CITY OF ALBUQUERQUE

October 28, 2022

**Re: Chick-Fil-A/ Extend the Drive-thru
8110 San Pedro Dr. NE
Traffic Circulation Layout
Engineer's/Architect's Stamp XX-XX-XX (C18-D042A)**

Based upon the information provided in your submittal received 10-13-22, the above referenced plan cannot be approved for Building Permit until the following comments are addressed:

C1.1

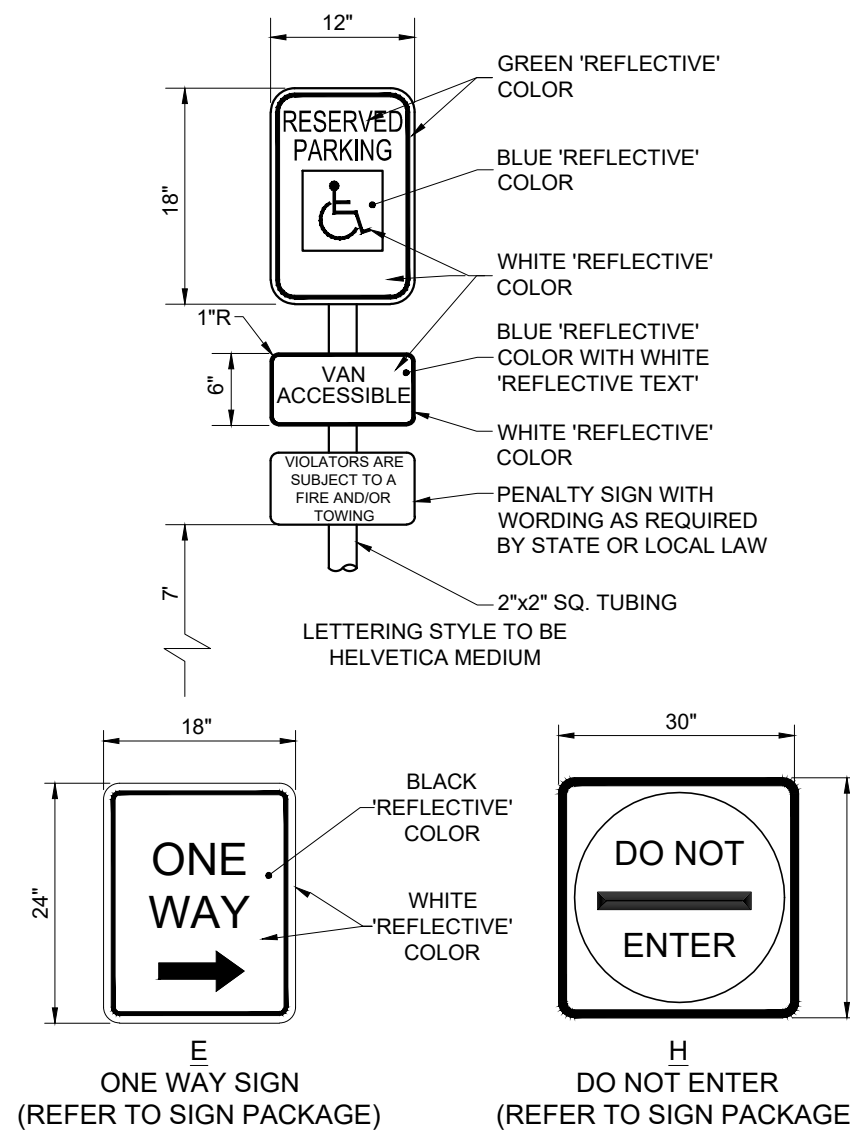
1. The traffic circulation layout must be stamped, signed, and dated by an engineer or architect licensed in the state of New Mexico.
2. Due to removing the parking spaces at the northeast side of the site, please provide new parking calculation indicate that the available parking spaces still meet the IDO requirements.

3. Due to removing the existing Bicycle Rack, List the number of Motorcycle and Bicycle parking spaces required by the IDO.
4. Shared access and shared parking agreement need to be provided with adjacent eastside property.

5. Provide the angle and the dimensions for all the existing angled parking spaces.
6. The ADA accessible parking sign must have the required language per 66-7-352.4C NMSA 1978 **"Violators Are Subject to a Fine and/or Towing."** Please call out detail and location of signs.

7. The ADA access aisles shall have the words **"NO PARKING"** in capital letters, each of which shall be at least one foot high and at least two inches wide, placed at the rear of the parking space so as to be close to where an adjacent vehicle's rear tire would be placed. (66-1-4.1.B NMSA 1978)

8. Provide "STOP" and "Do Not Enter" signage and pavement marking at the south east side of the drive-thru lanes.
9. ADA curb ramps must be updated to current standards and have truncated domes installed.

10. Motorcycle parking spaces shall be designated by its own conspicuously posted upright sign, either free-standing or wall mounted per the zoning code.

11. The pavement marking "MC" should be shown in the opposite direction for motorcycles entering the parking space.

12. All bicycle racks shall be designed according to the following guidelines:
 - a. The rack shall be a minimum 30 inches tall and 18 inches wide.
 - b. The bicycle frame shall be supported horizontally at two or more places. Comb/toaster racks are not allowed.

13. Bicycle racks shall be sturdy and anchored to a concrete pad.
14. A 1-foot clear zone around the bicycle parking stall shall be provided.
15. Bicycle parking spaces shall be at least 6 feet long and 2 feet wide.

16. Please specify the City Standard Drawing Number when applicable.
17. Add a note stating "All broken or cracked sidewalk must be replaced with sidewalk and curb & gutter." A build note must be provided referring to the appropriate City Standard drawing.
